Recommendation Report for Planning Permission

REF NO: EG/21/17/PL

LOCATION: Eastergate Water Treatment Works
Fontwell Avenue
Eastergate

PROPOSAL: Application for Variation of condition No.2 following the grant of planning permission EG/22/15/PL relating to colours of building, road layout, landscaping & drainage details. Resubmission of EG/3/16/PL

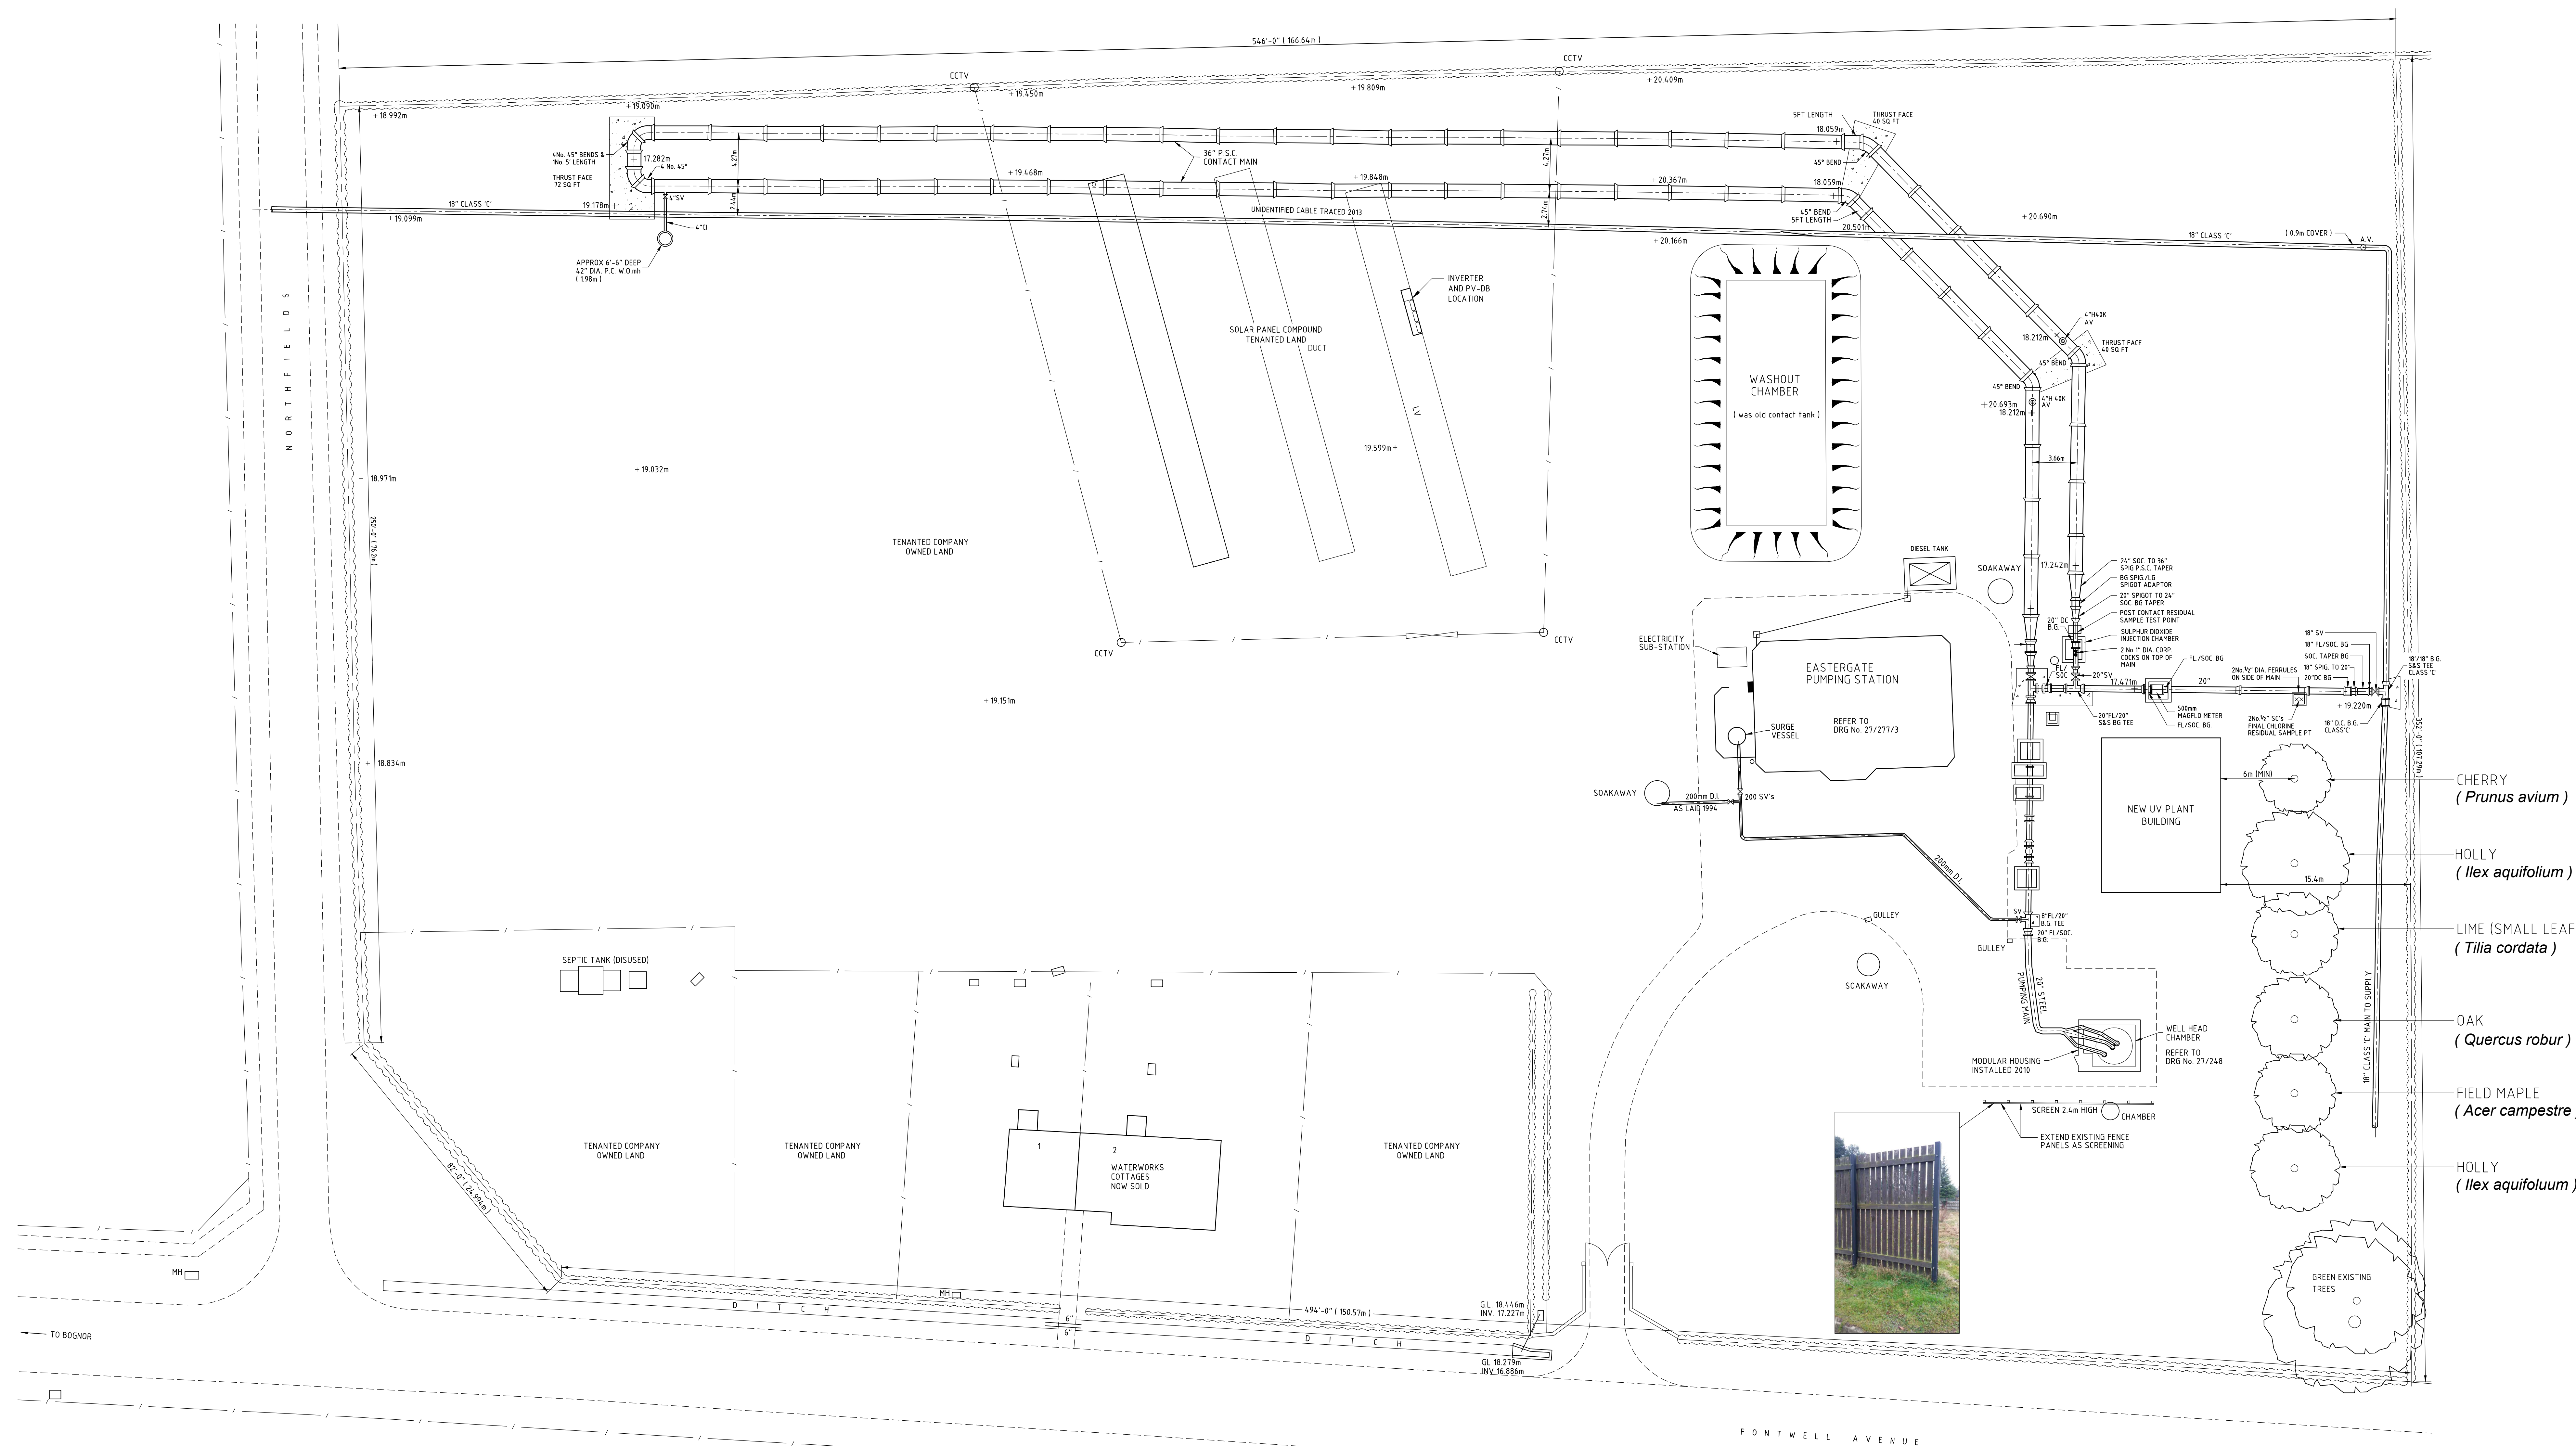
ADC LANDSCAPE OFFICERS: Originally objected due to the landscape plan failing to show the Latin names of trees, quantities and the size of the trees at the time of planting. Following the submission of an amended plan, commented that: "I can confirm that I would now recommend to planning no objection to the proposals submitted and that the drawing now includes the previously lacking information."
